January 10, 2014

**Subject: Sheridan Street Apartments  
Final Site Plan Application  
Response to Peer Review Comments**

**L-1**

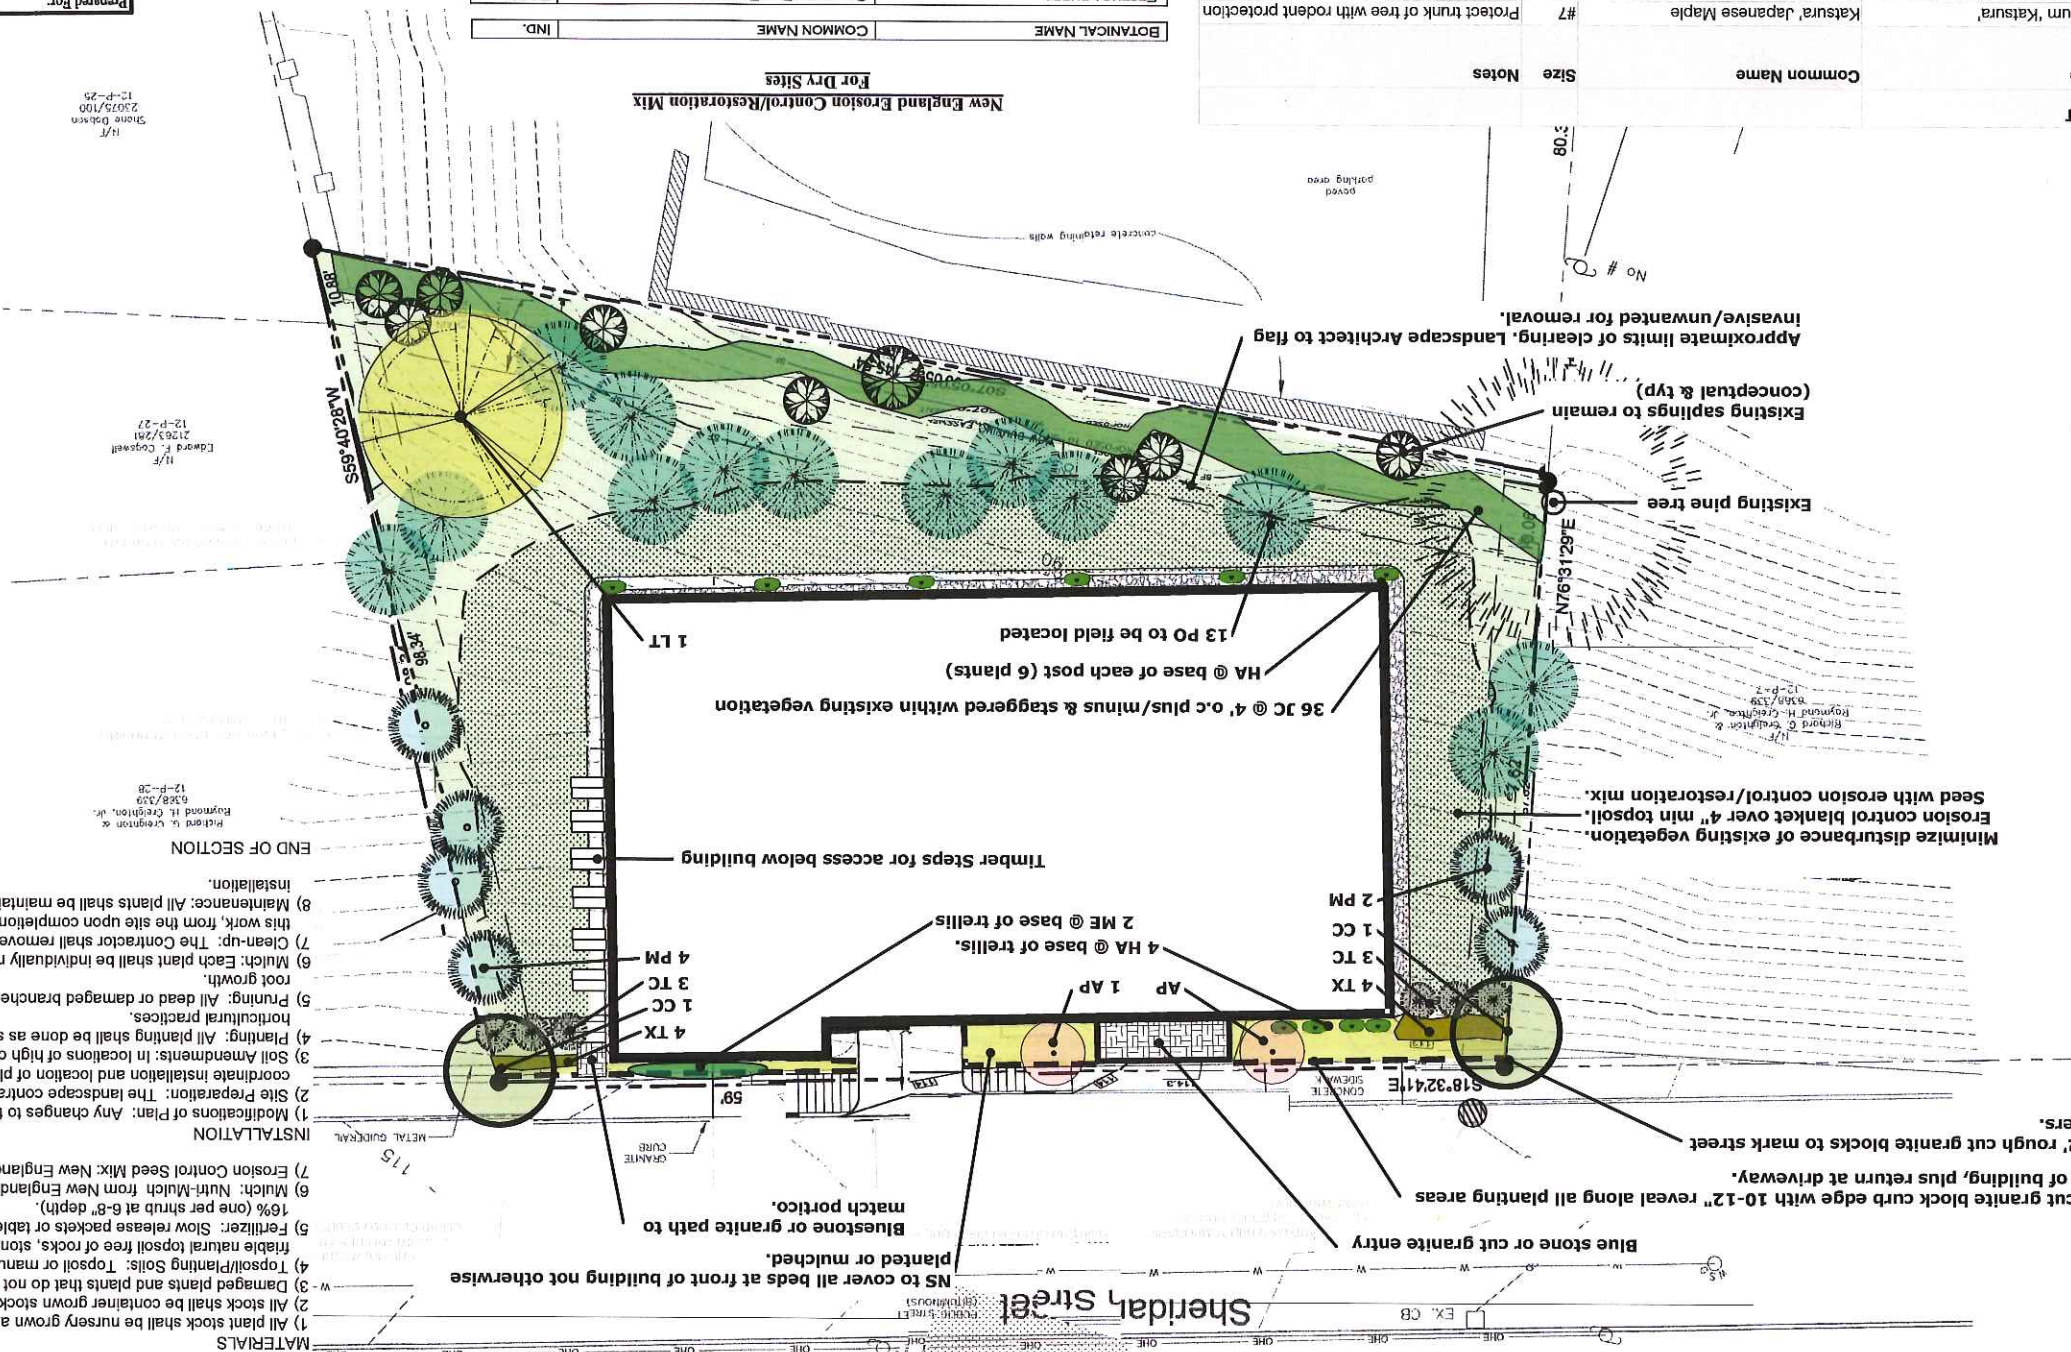
*The board (and city staff) talked quite a bit about crime prevention through environmental design and that under-building area. Can you address this concern directly? I see quite a bit of detail on landscaping, but no other access control to speak of.*

*Likewise, some board members raised concerns about maintenance of this area. I see that stairs have been added, but can you address this as well?*

In discussions with the board, we understood that they asked that we provide a thorny shrubbery to make climbing up the slope uninviting. We have provided this in the landscape plan. The intent of the planting plan on the lower slope is to grow a green wall with a native feel that will over time mask the foundation and occupy the entire slope with dense and woody, sharp-needed plants. Serbian Spruce and Chinese Juniper together are intended to make up the backbone of that wall, but existing plants should grow and spread as well. Species such as Oak, Pine, and Staghorn Sumac are among those observed on site. The overall impression is intended to be that of a dense native thicket on very steep ground with space not easily occupied.

All of the landscaping on the slope requires little to no maintenance. It is basically a natural ground cover shrubs and trees very close to a natural woodscape. The woods stairs will allow residents the chance to use the below deck space for storage such as kayaks, lawn chairs or related items.
